AB/61/21/L

61 Maltravers Street Arundel BN18 9BQ

Listed building consent to reduced chimney height.

EXISTING ROOF PLAN

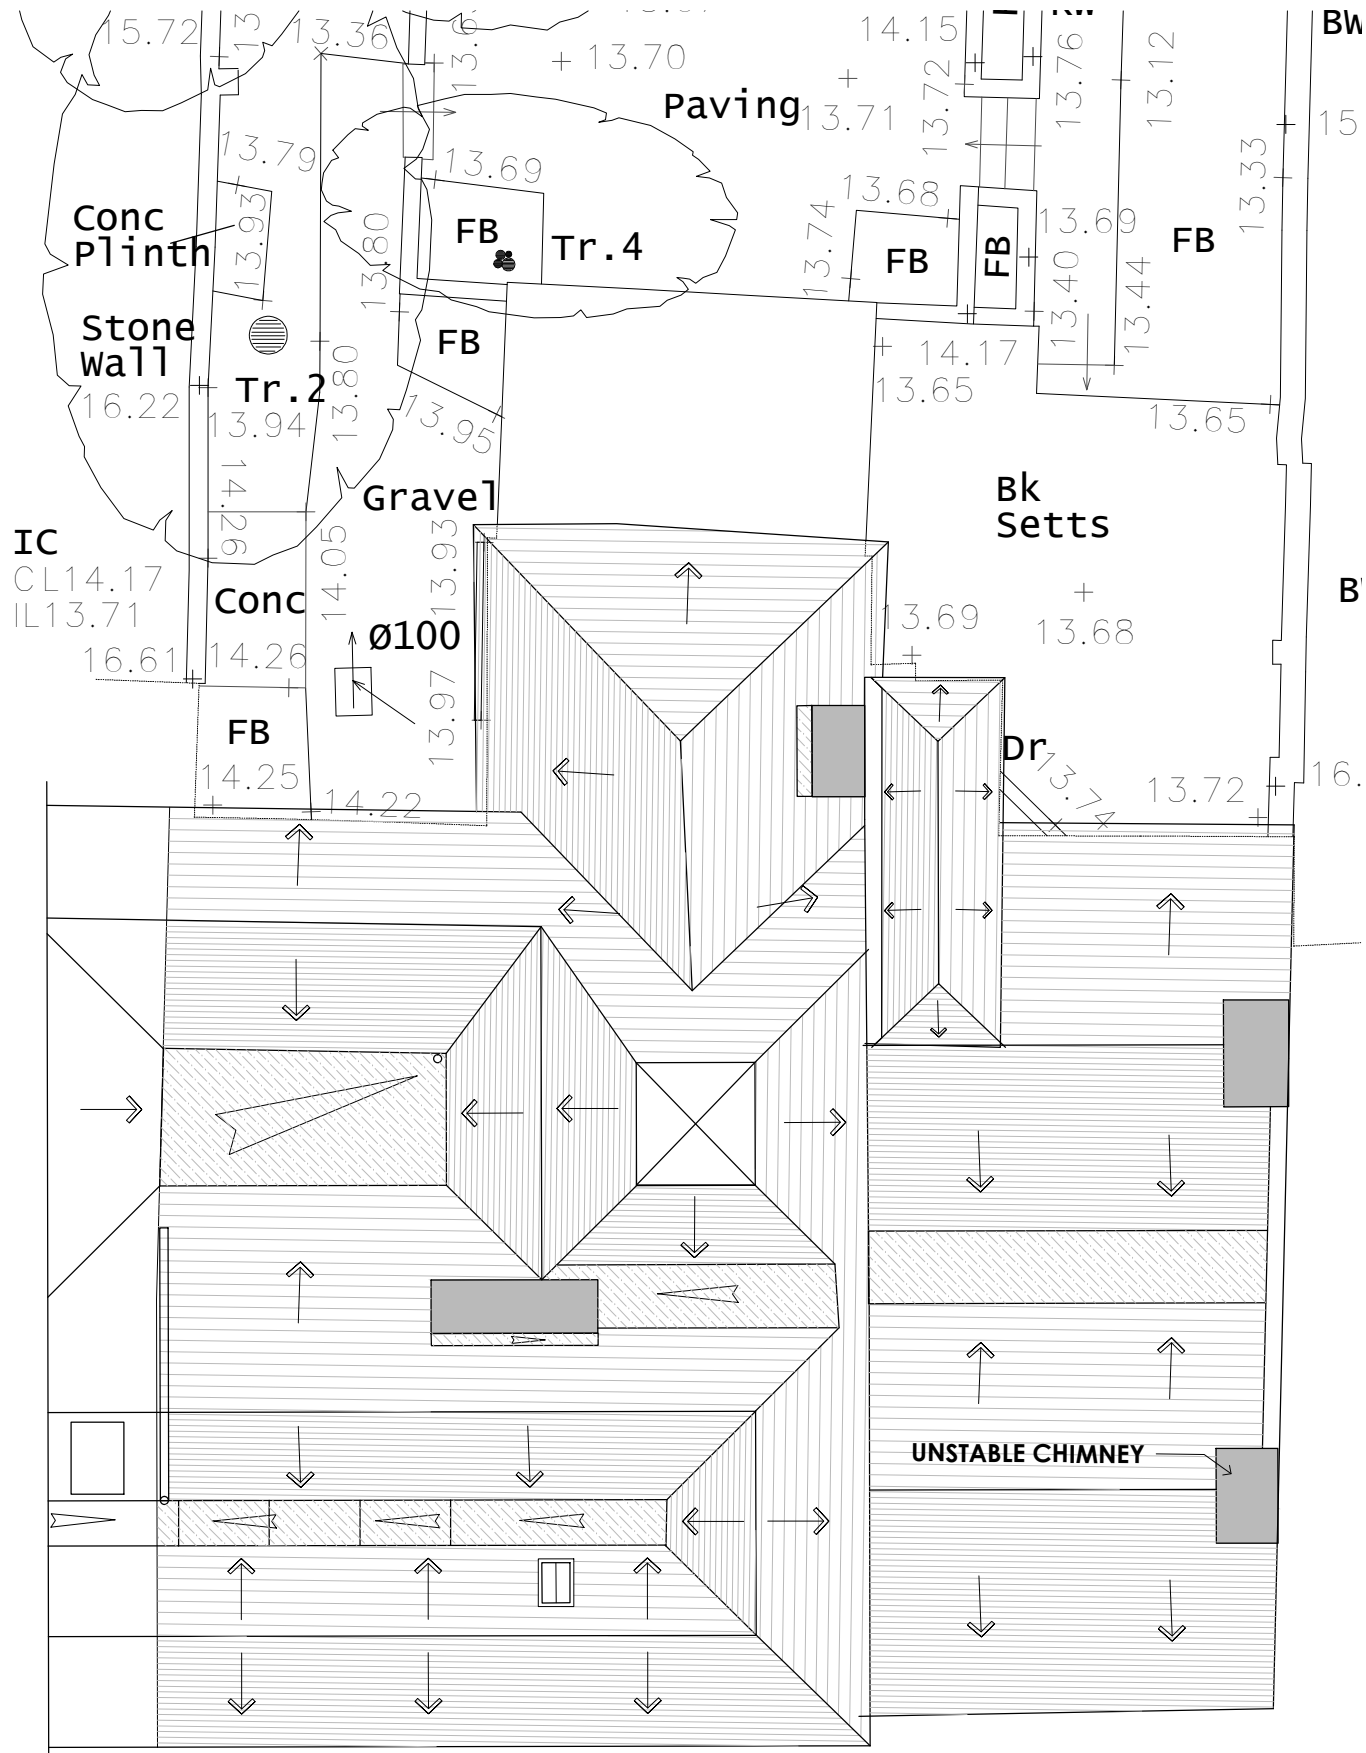
The proposal is to reduce the height of the chimney in the western, two storey element of the property. This chimney is a prominent feature in the Maltravers Street-scene, especially when viewed from the raised pavement on the other side of the road.

Having read the application details it would appear that, rather than just reduce the height of the chimney, the intention is to dismantle it and rebuild it to a lower height. This is considerably

As a conservation officer, I am not qualified to deal with issues of a structural nature, and have to rely on others, especially when it comes to matters of safety. However, it is not clear if any alternative options have been investigated which would enable the chimney to be rebuilt to its previous height, which is disappointing.

As a prominent structure, I would want to make sure that the existing bricks, bonding, mortar and design would be closely replicated in any replacement, so that it closely reflects the existing chimney and does not cause harm. These details could be provided for by way of condition if you are minded to approve the application.
